Final Report - Corrections Required **Application No. DEPN-24-0160**

Description : Multi-family development with 170 rental duplex units on one development lot. Also a request for alternate landscape compliance related to placement of streamside overly and property boundary buffer plantings, and to be allowed to provide 9.4% active open space where 10% is required.

Address : 2210 Old Ranch RD Colorado Springs CO 80920

Document Filename : Cottages at Kettle Creek DP_1st_Submittal_101524.pdf

## STREAMSIDE CRITERIA

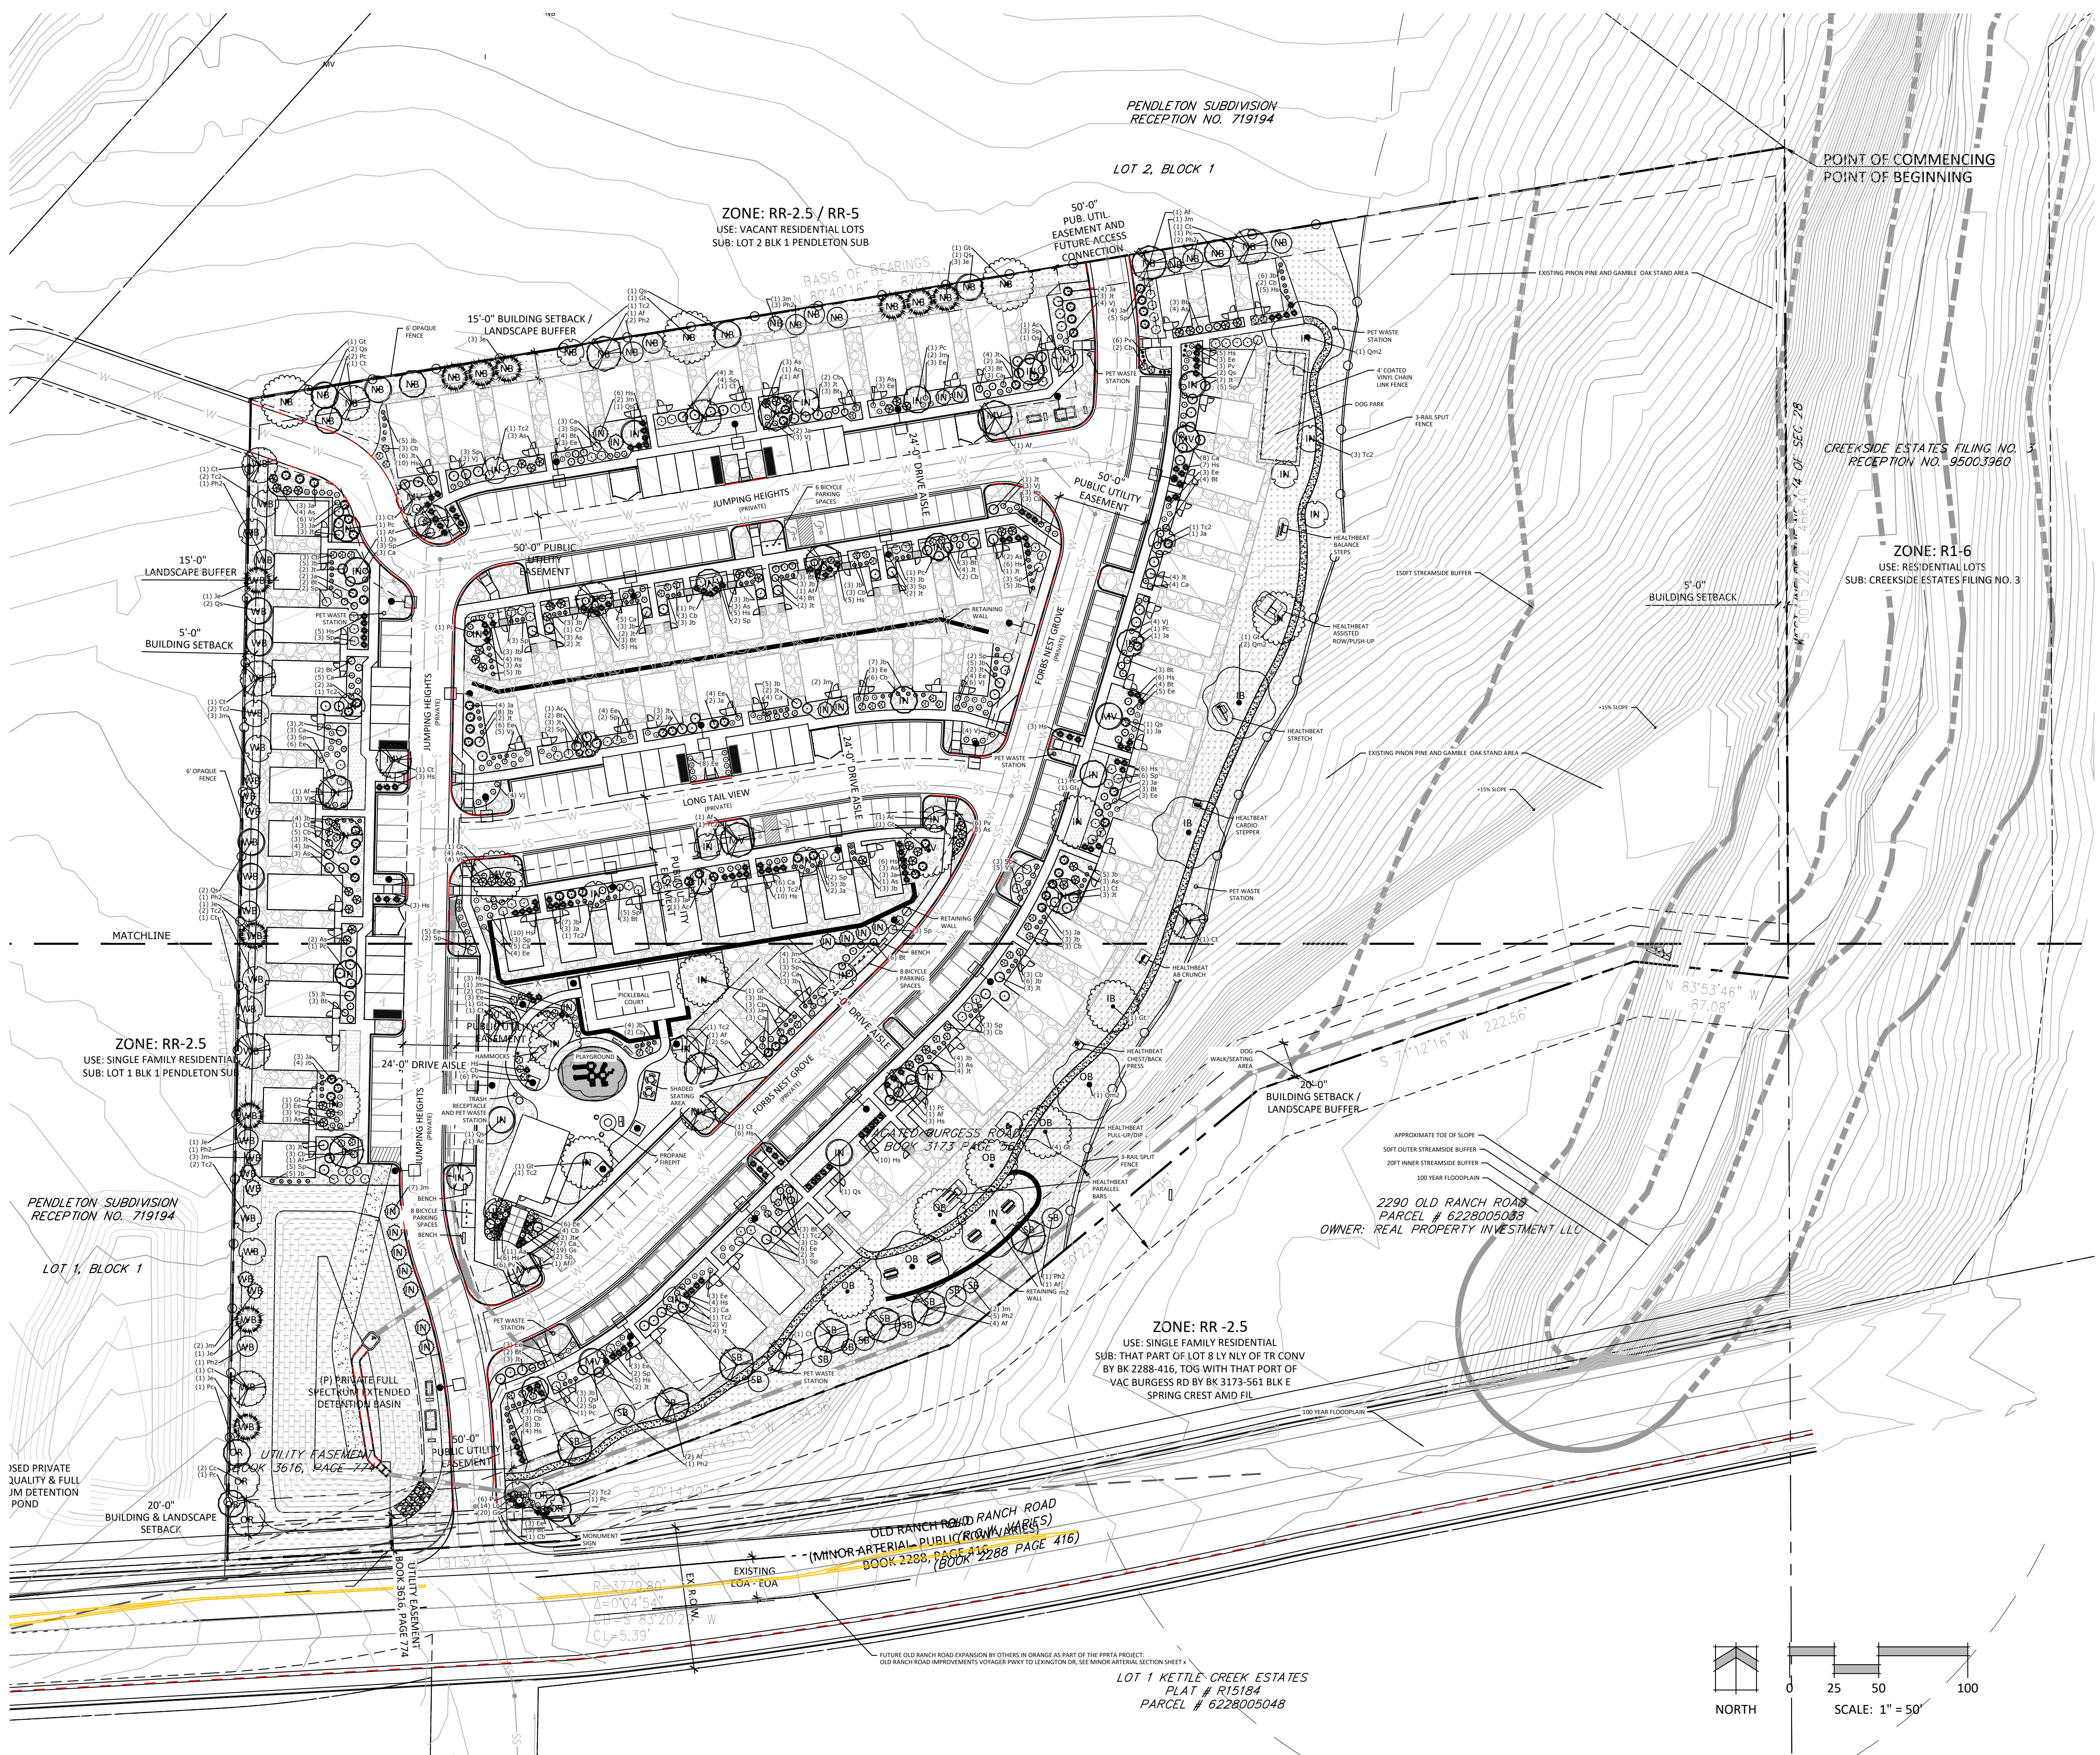
11	8	Gregory Stachon : Planning	what do blue and green areas represent? Ground plane legend would be helpful on this page
1	10	Allison Stocker : Planning	Regarding Water Capture Volume and the SS-O, did you previously have discussions with SWENT / Planning Staff to confirm that the water quality on site meets the criteria for this added max impervious coverage? If this was not discussed and not "approved", then we should clarify that up to 25% is permitted IF Planning and SWENT sign off on the Water Quality Capture Volume methods on site. Otherwise the max is 10%.
17	10	Allison Stocker : Planning	Please show the storm sewer outlet pipe that encroaches into the SS-O buffer areas on SS-O plan.
20	10	Allison Stocker : Planning	Please add a note related to the storm outfall pipe that describes what replanting efforts and other mitigation will be provided to offset impact of pipe installation. Please note species of plants that may be installed in these areas. You may want to discuss with Greg Stachon to confirm that the species are viable and acceptable for this purpose.
